RE: Lovelace Heights Addition – 2121 Yale Blvd SE
Erosion and Sediment Control Plan
Engineer's Stamp Date (missing) (M15E021)

Please find below our comment responses addressing the ESC Plan first review. This letter is to address comments we received from you on May 24, 2022. To facilitate your review, we have included the original conditions in *italicized* font and have provided our responses in **bold blue**.

C6.5

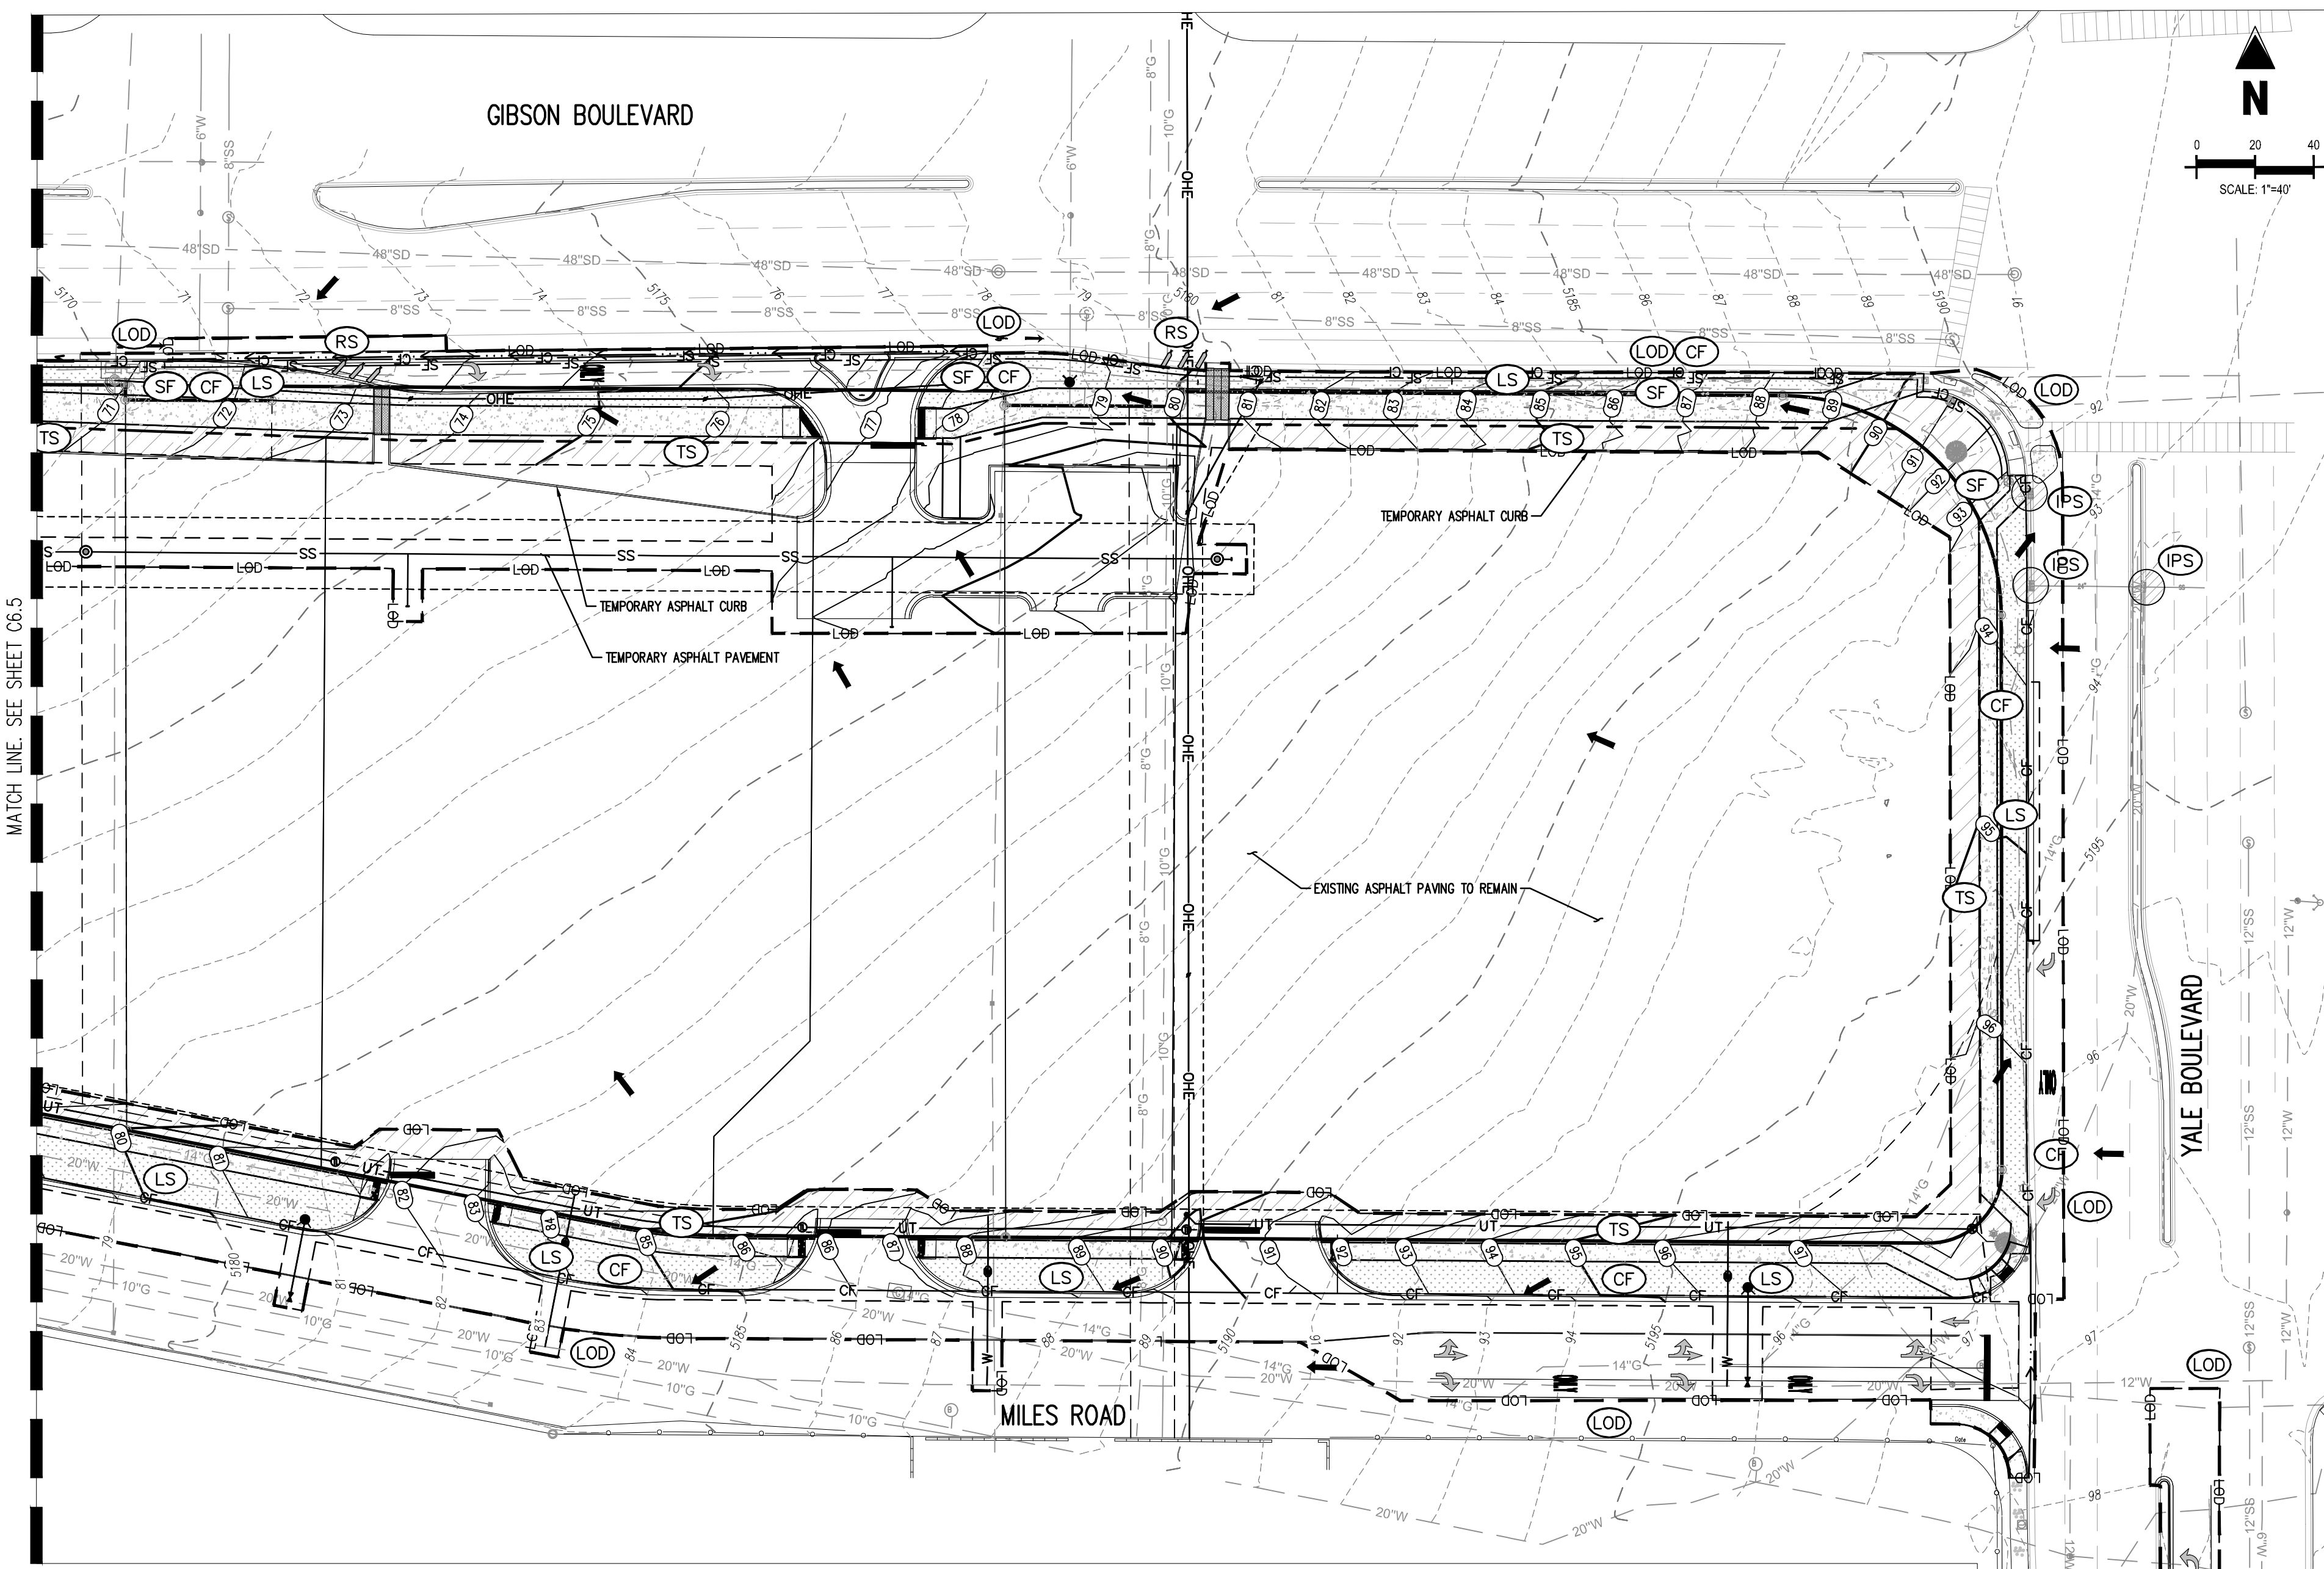
8. The SWPPP must include site-specific interim and permanent stabilization per CGP 9.4.1.c.i. The Landscape Plan and Work Order sheets can be used to satisfy this requirement and should be submitted separate from the ESC Plan with the application to the Stormwater Quality Section of the Planning Department and they should be included in the SWPPP. Provide a specification on the ESC Plan for any disturbed areas not covered by the Landscape Plan or Work Order sheets, especially the areas labeled TS on sheets 6.5 and 6.6.

Response: Acknowledged, Conceptual Landscape Plan included separately to show permanent landscaping. Additional information added to TS labels, see Erosion Control Legend sheets C6.5 and C6.6.
